October 26, 2017

RE: Review Agency Responses – Gateway Church Bell Tower Site Development Plan – PPR-17-039  
Proposed Bell Tower, 5605 N. Marksheffel, Colorado Springs, CO 80922

Please accept this letter as formal reply and answers to your letter of October 10, 2017, regarding the Reviewing Agency response comments to the application for Site Plan/Plot Plan Review submitted by Branch Communications (Applicant). Each Agency comment is addressed individually.

Z1.1

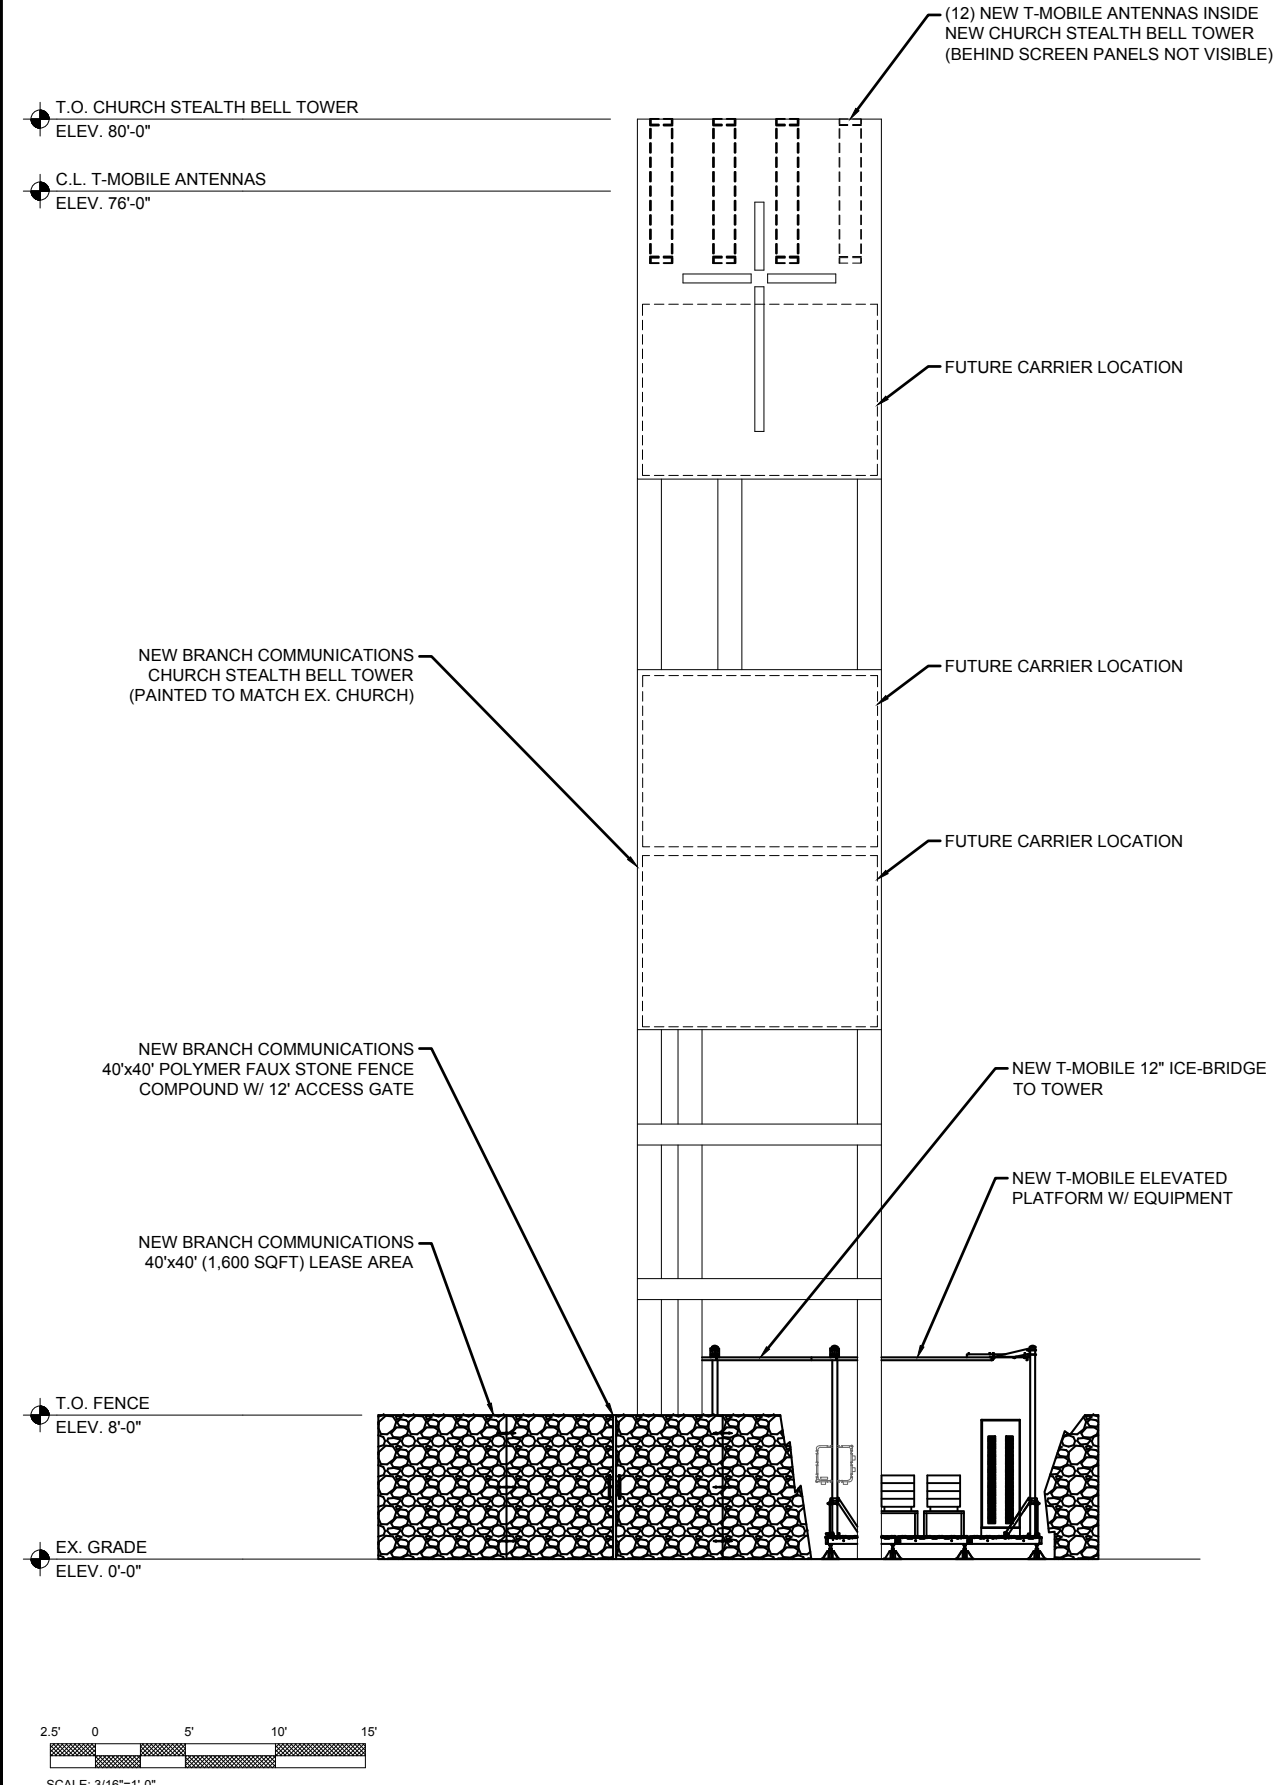
- The 8' fence is considered an accessory structure, must meet setbacks and will require a building permit.

**Applicant Response - Applicant acknowledges and believes the tower location and fencing for the leased premises satisfies all setback requirements. Applicant will include fencing in the building permit application.**

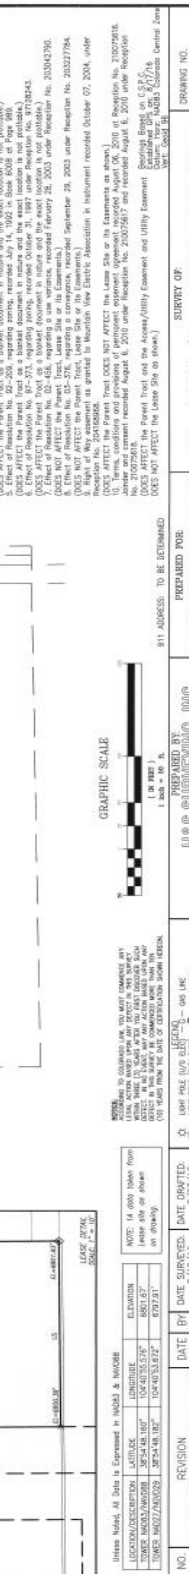
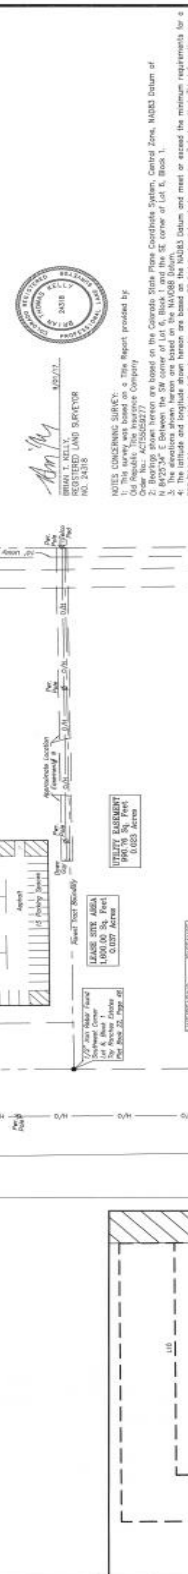
1. Ensure existing utility easement (label 10) is shown in the correct location. Item has not been addressed.

2. Accurately show and label existing 50' easement to include reception number or book and page. Easement is currently shown encompassing most the detention pond, revise as appropriate.

**Applicant Response – Applicant has assurance from the surveyor that existing utility easement (label 10) is shown in the correct location on the revised survey and resubmitted.**

**Applicant Response – Applicant's revised survey shows an existing 50' easement in correct location and the Reception number is included on the survey.**
